10th January 2013

Application for Householder Planning Permission

Development Ground floor rear and side extension with roof extension.
Location Spinneys West Walberton Lane Walberton

1:500 site plan

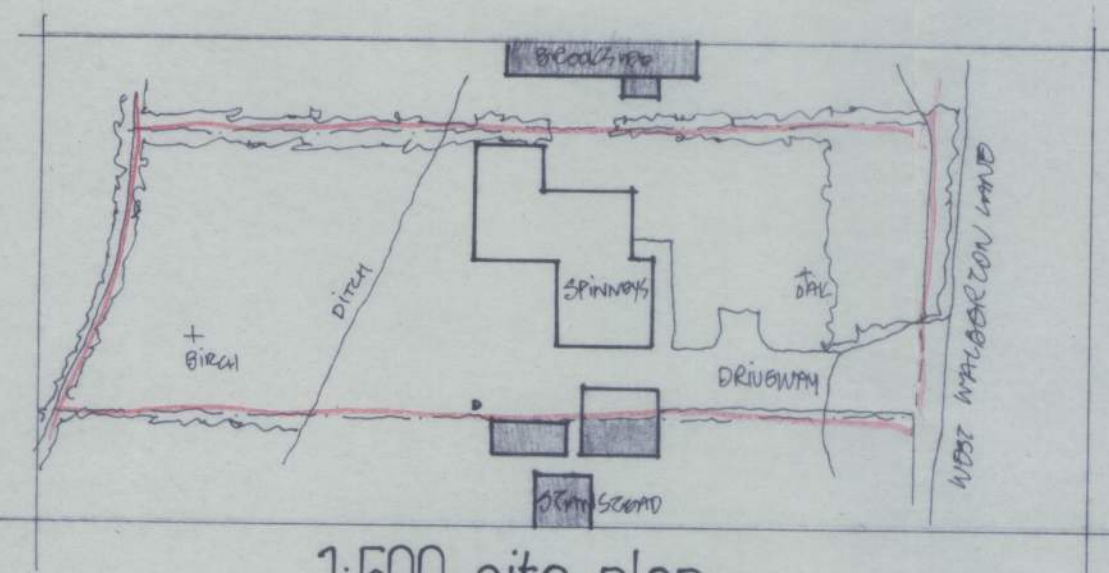
Please submit 1 electronic or 3 paper copies of an amended block/site plan at a scale of 1:500 with the proposals clearly highlighted in accordance with the guidance notes available on our website detailed below (click on National List). (The block plan provided is not to scale and the site plan does not include the proposals).
